Ref: 20765.200424.L1

20765: ADDENDUM TO KR ASSOCIATES REPORT, EVEREST HOUSE DEVELOPMENT, SOPERS ROAD KR06604

Details on the refusal of the planning application (ref: 6/2020/0447/PN11) state that concerns have been raised over the internal noise levels within habitable spaces with open windows. The following letter outlines a peer review of the KR Associates Report and gives recommendations to the Local Authority.

Drawing title
Proposed Lower Ground
and Ground Floor Plan

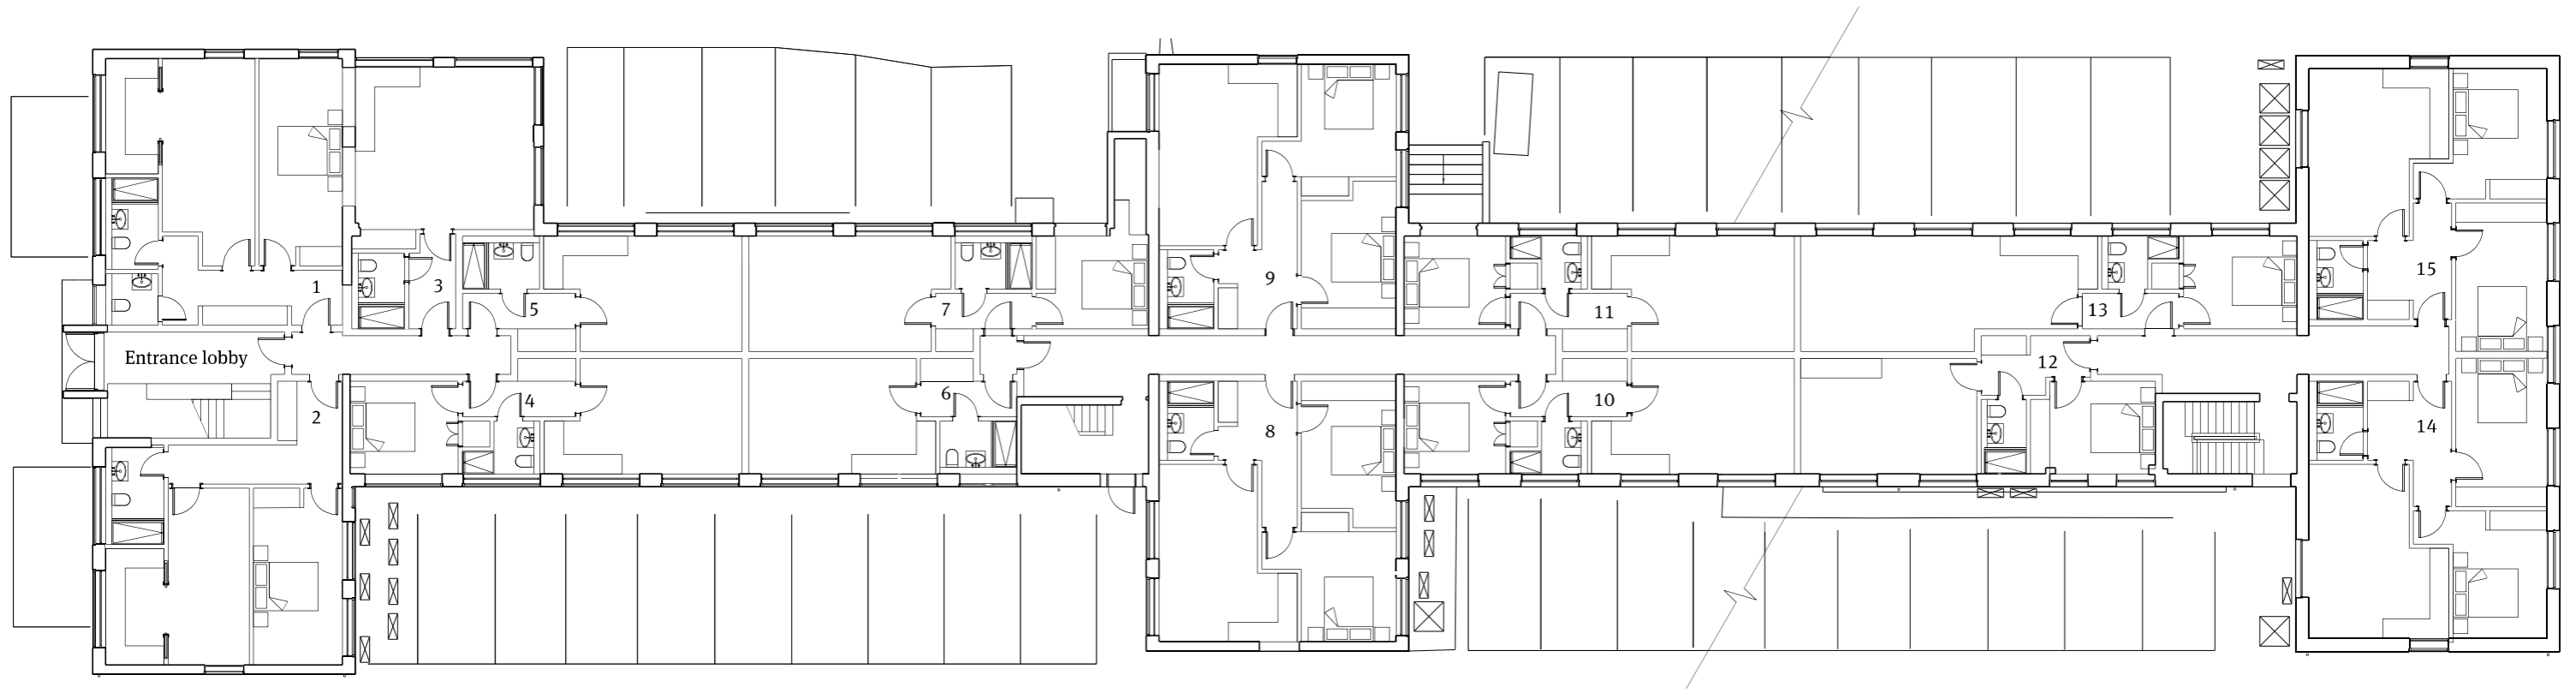
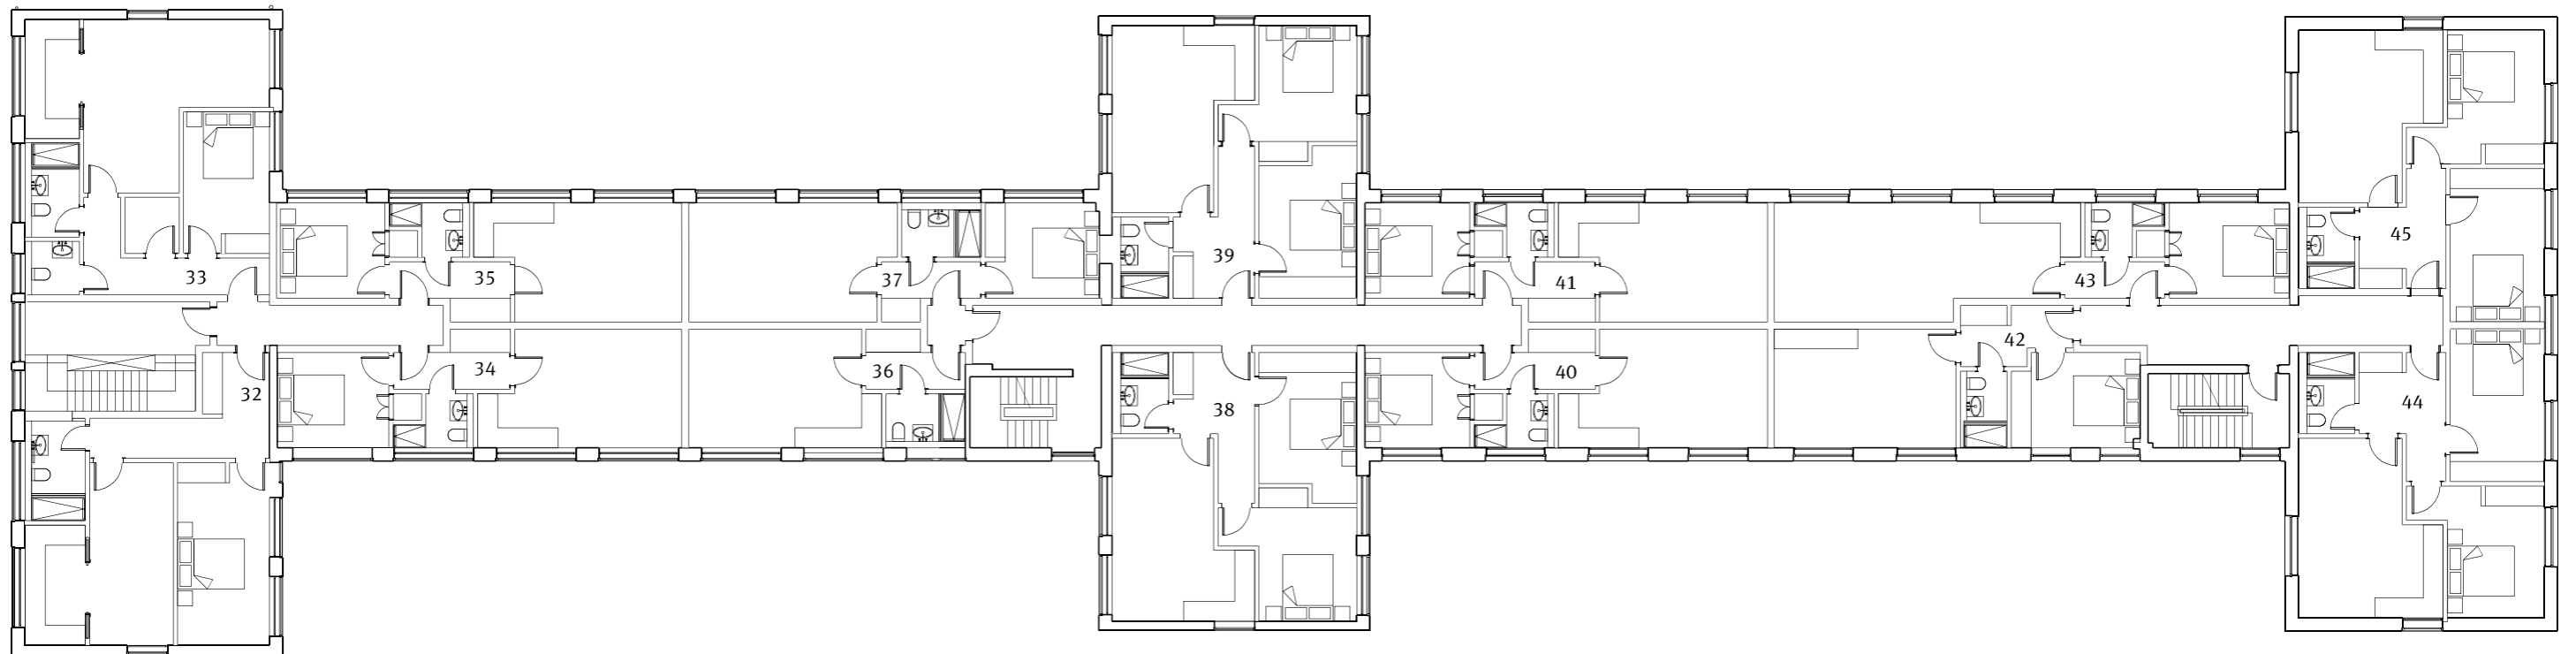
The internal layout of the development has been amended since the issue of the KR Associates report (ref: KR0660), so that the highest level of external noise due to surrounding units incident upon any habitable room is now 64dB $L_{Aeq, hour}$ (i.e. 9dB lower than the previous prediction). Based on the KR Associates calculations, this would reduce the highest internal noise level with open windows to **40dB $L_{eq,T}$** and with closed windows to **17dB $L_{eq,T}$** during both the daytime and the night-time.

With the new proposed layout, it is possible to reduce internal noise levels to 17dBA with the use of mechanical ventilation and secondary glazing. With recalculation of source noise levels due to a reduction in on-time, it is likely that this could be reduced even further.
